From: wilpshire parish council <wilpshireparishcouncil@gmail.com>
Sent: 12 November 2019 07:14
To: planning; wilpshire parish council
Subject: Planning Comments

3/2019/0925 fence and gate at Roundhay, 69 Whalley Road, Wilphshire

Anderson Road Elevation
1:100 @ A2

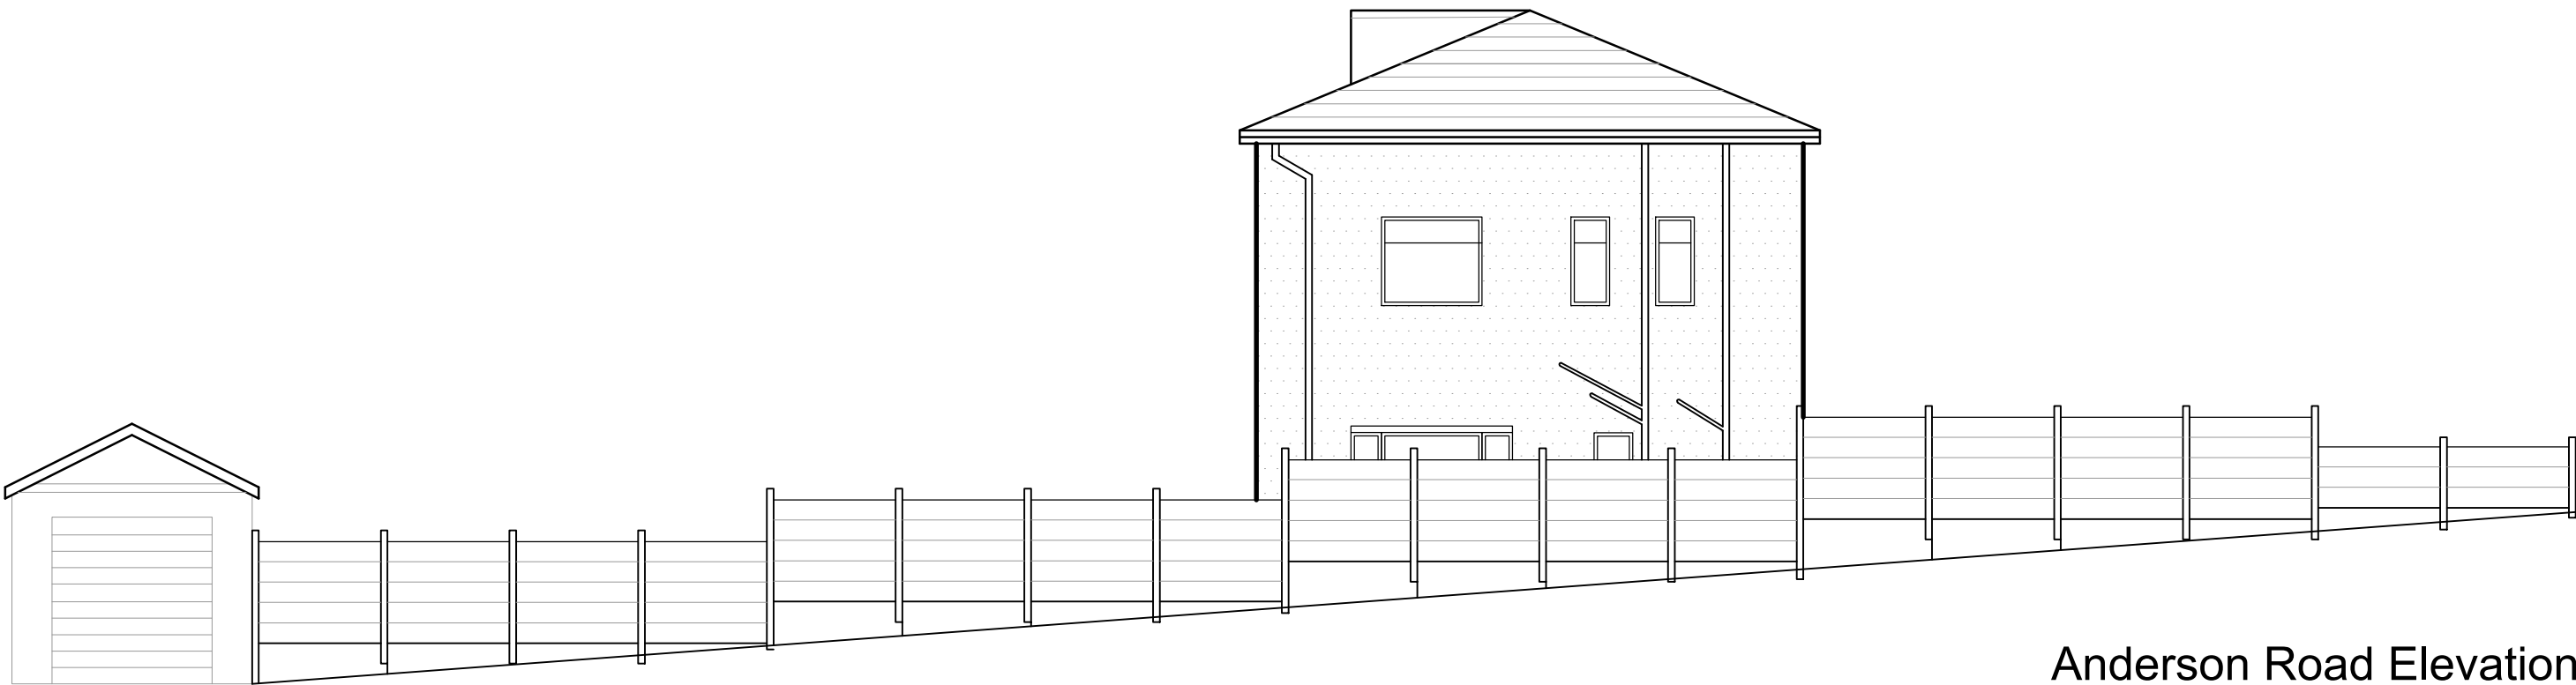
WPC objects as the proposed fence would have an adverse effect on the street scene. It is out of character with the whole of Anderson Road and, because of the slope, will be 7ft high in numerous parts being almost as high as the garage door.
